Our Case Number: ACP-323851-25

Re: Proposed construction of the Celbridge Hazelhatch Mobility Corridor
Celbridge Town, County Kildare

Submission Regarding the Celbridge Hazelhatch Mobility Corridor Section 177 AE Planning Application (An Coimisiún Pleanála Case Reference: JP09.323851)

TYPICAL DECK CROSS SECTION

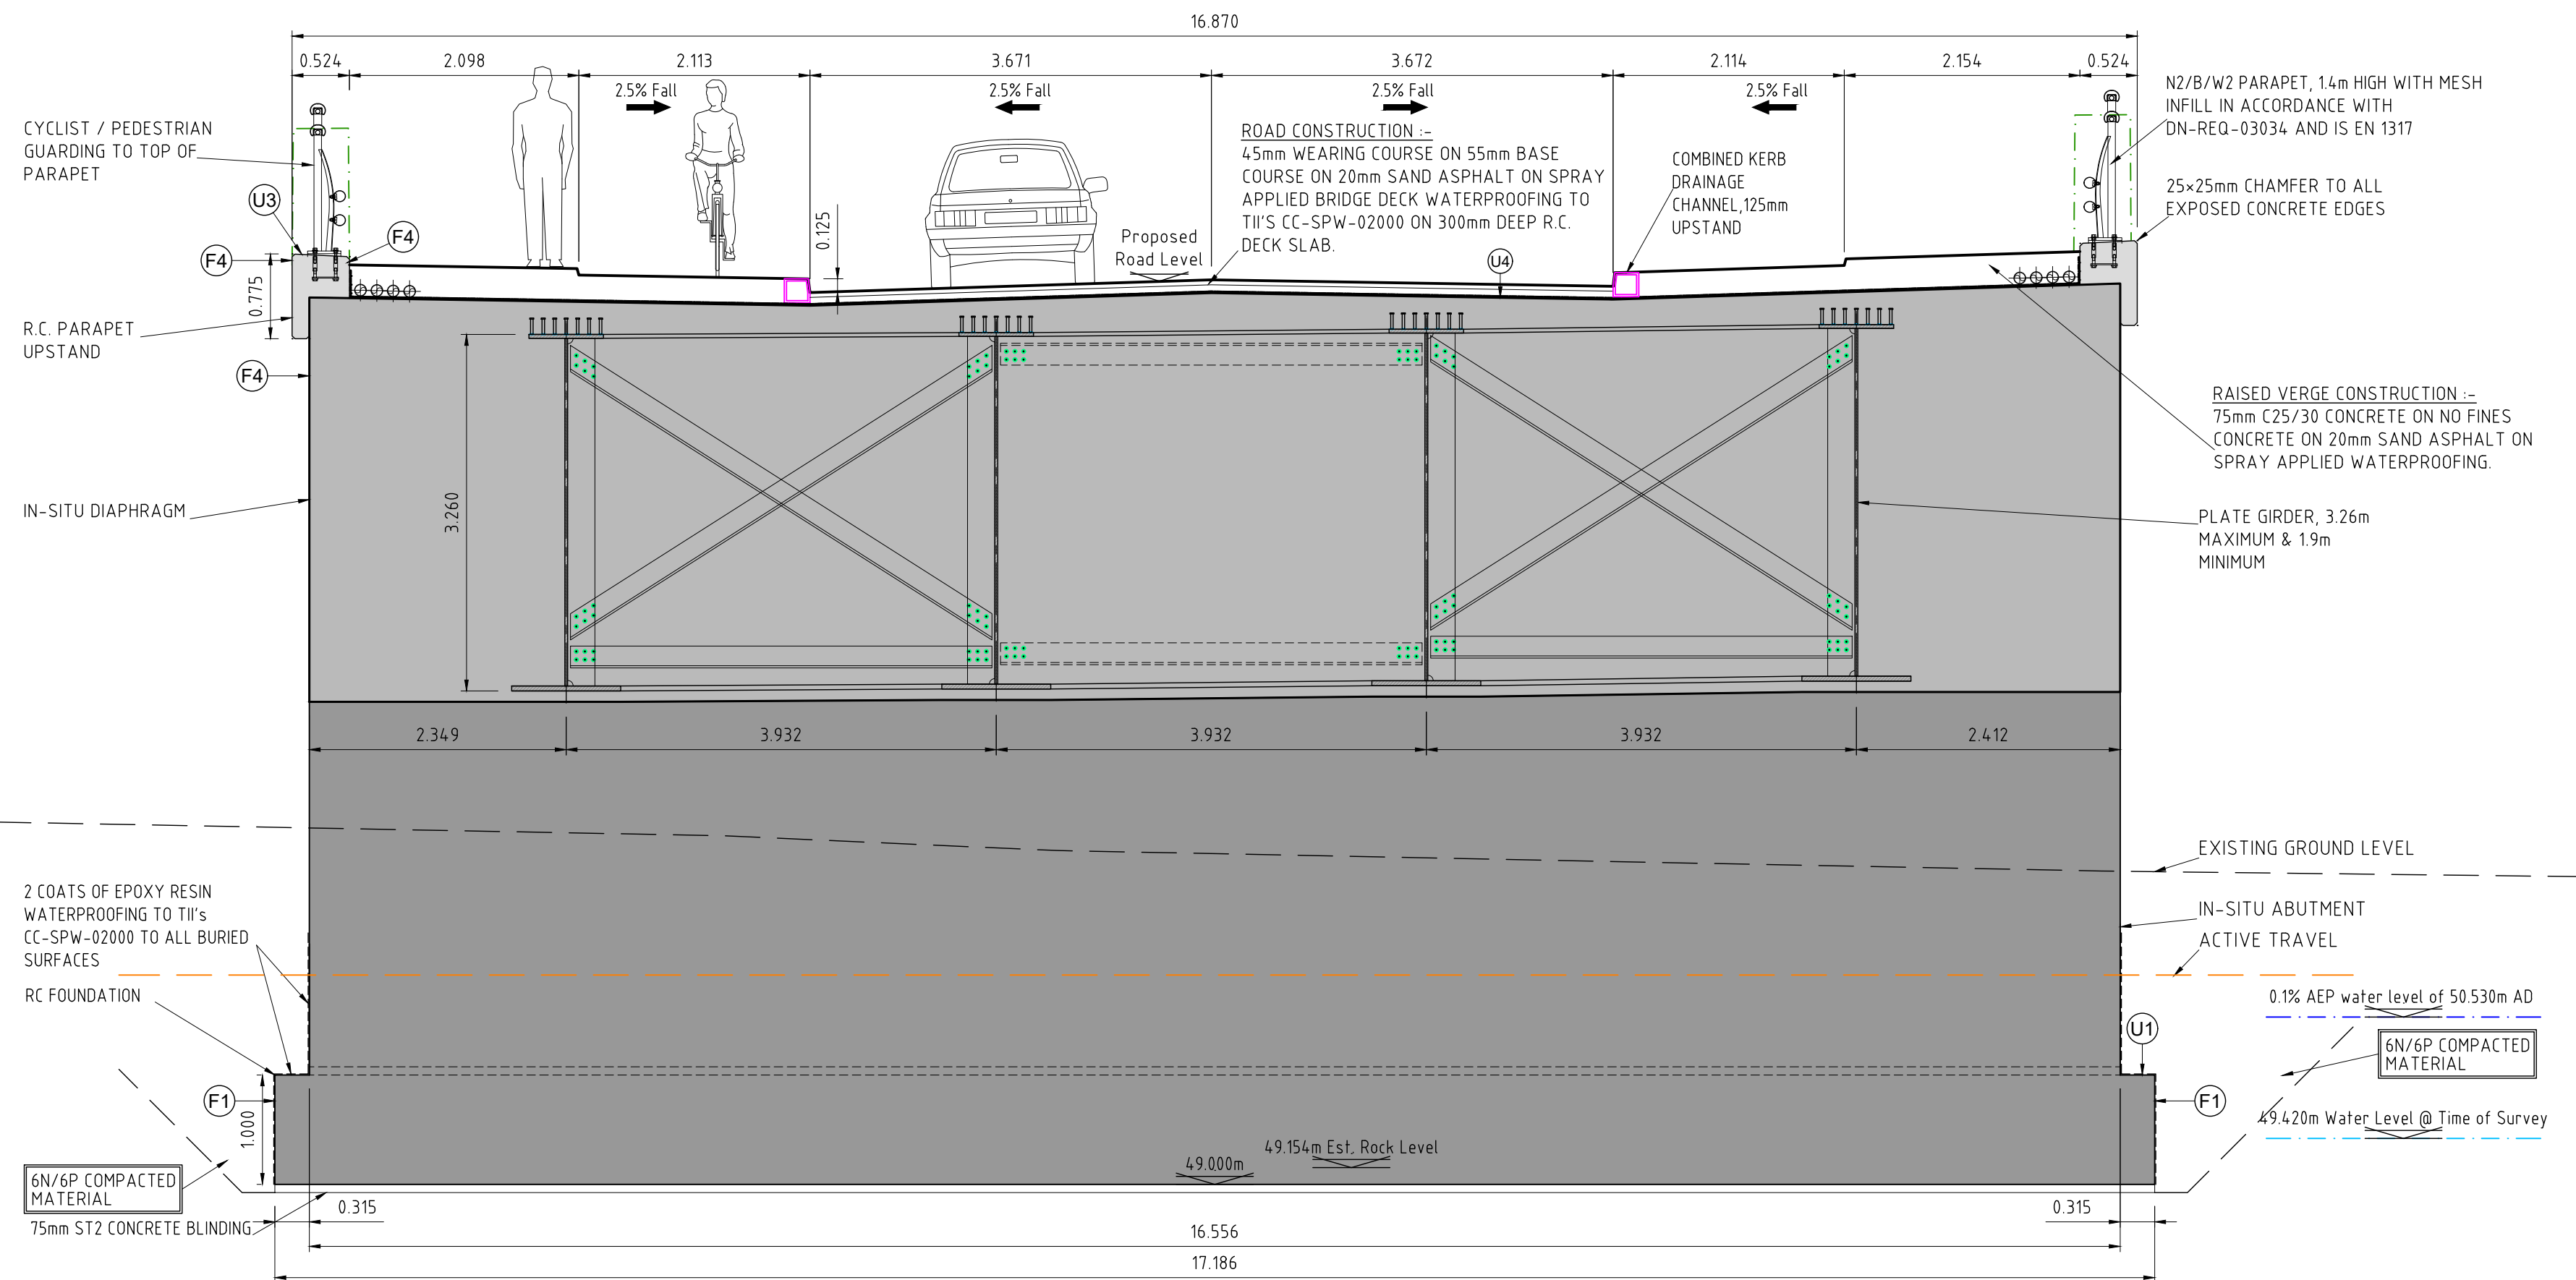
- The design features—walled abutments, and arched weathered steel girders—result in an imposing, utilitarian structure that blocks landscape views and creates a sense of enclosure beneath the bridge.

- The mesh covered parapet, guardrail, and street lighting are more appropriate for a motorway overpass than for a bridge in a sensitive landscape, as seen in recent unsuitable examples like the bridge over the Lyreen River in Maynooth.

Figure 17: Cross-section including proposed lighting from SHEET 3 General Arrangement

- Achieve a context-sensitive aesthetic.
- Ensure a less dominant form and a more sympathetic appearance, including parapets, guardrails, and lighting.
- Consider the safety of cyclists and pedestrians using the underpass with a more open feel.
- Include photomontages from multiple extra viewpoints, including within open spaces and during winter, to provide a realistic assessment of visual impact from all angles.
